CITY OF ALBUQUERQUE

April 4, 2018

RE: Homewood Suites - 5400 San Antonio Dr. NE
Grading and Drainage Plan
Engineer's Stamp Date 3/16/2018
Hydrology File: E18D050

CITY OF ALBUQUERQUE			
TITLE HOMWOOD SUITES STORM DRAIN PLAN & PROFILE			
DESIGN REVIEW	ENGINEER APPROVAL	MO/DAY/YEAR	MO/DAY/YEAR
PROJECT NO.	735186	ZONE MAP NO.	E-18
SHEET	3	OF	3

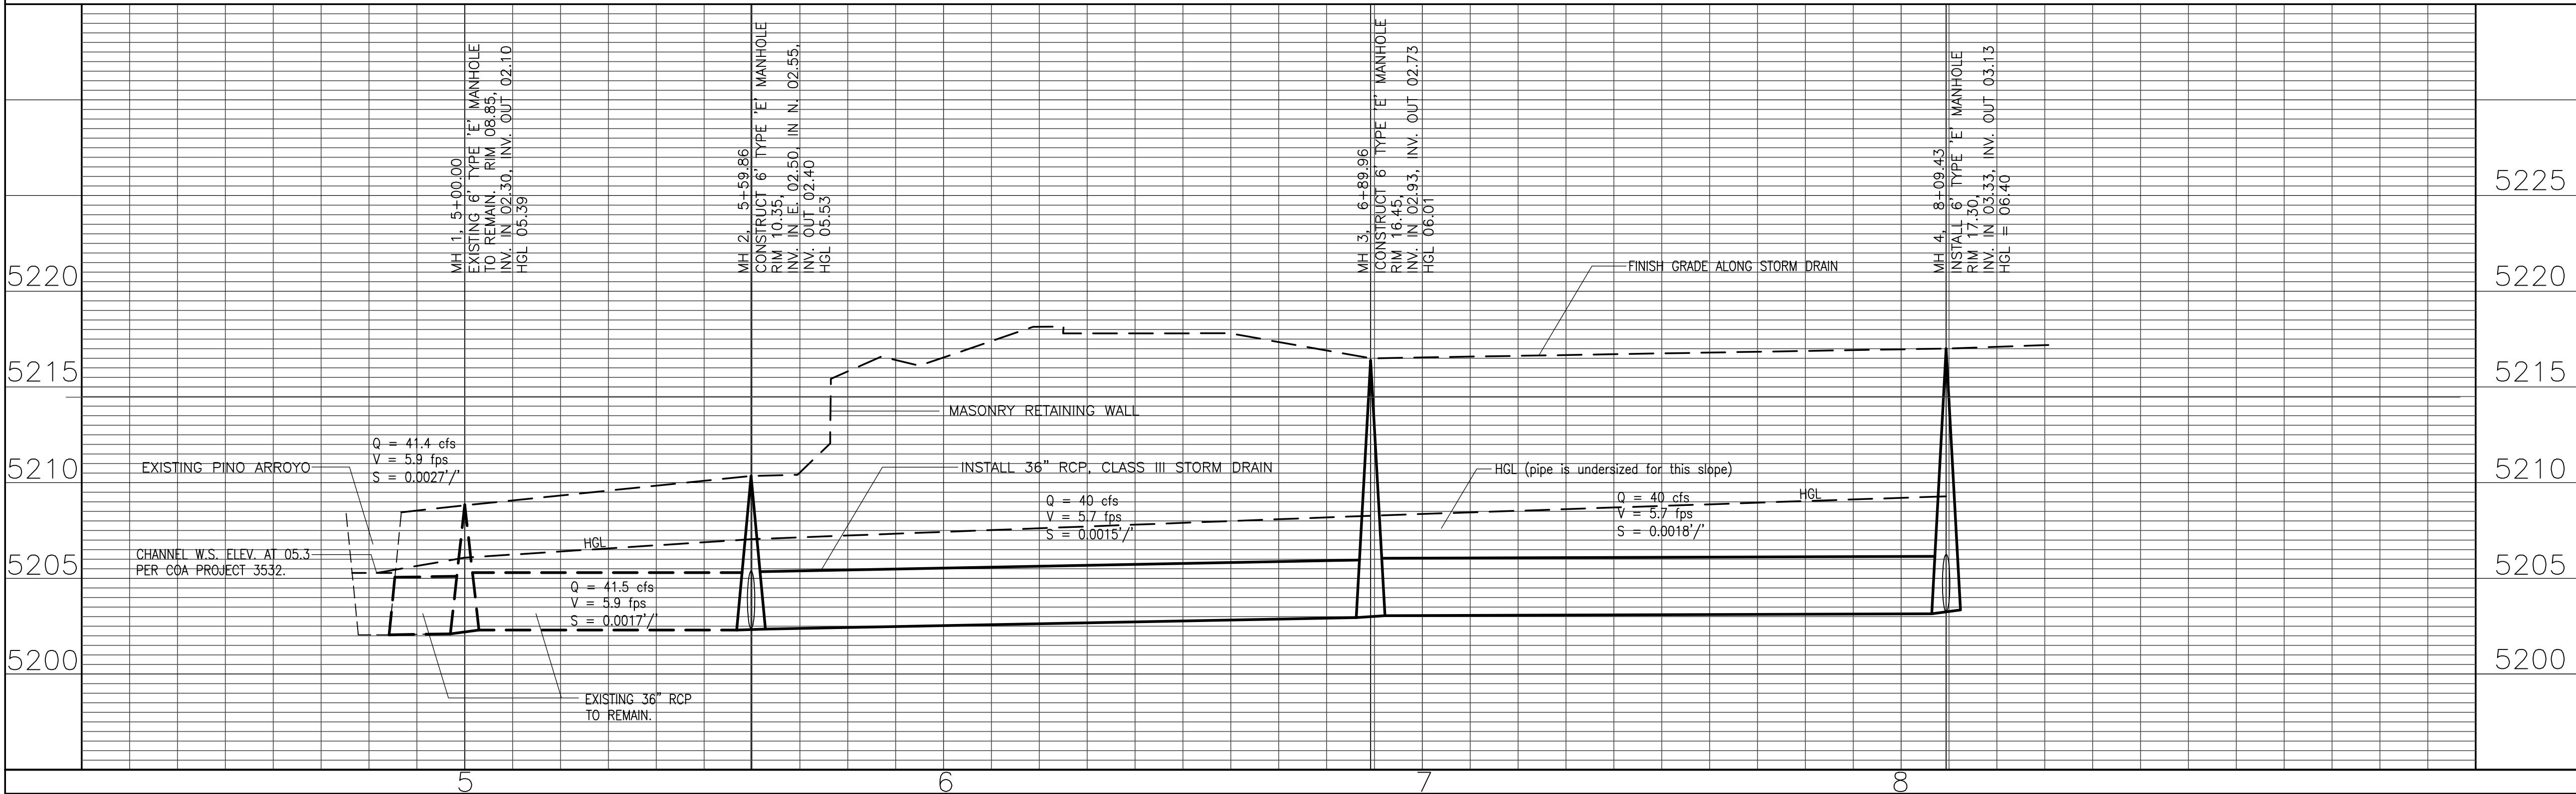
3. Add note 1 above to the DRC Plan & Profile sheet.
4. Remove the note on the plan & profile sheet that says "pipe is undersized..."
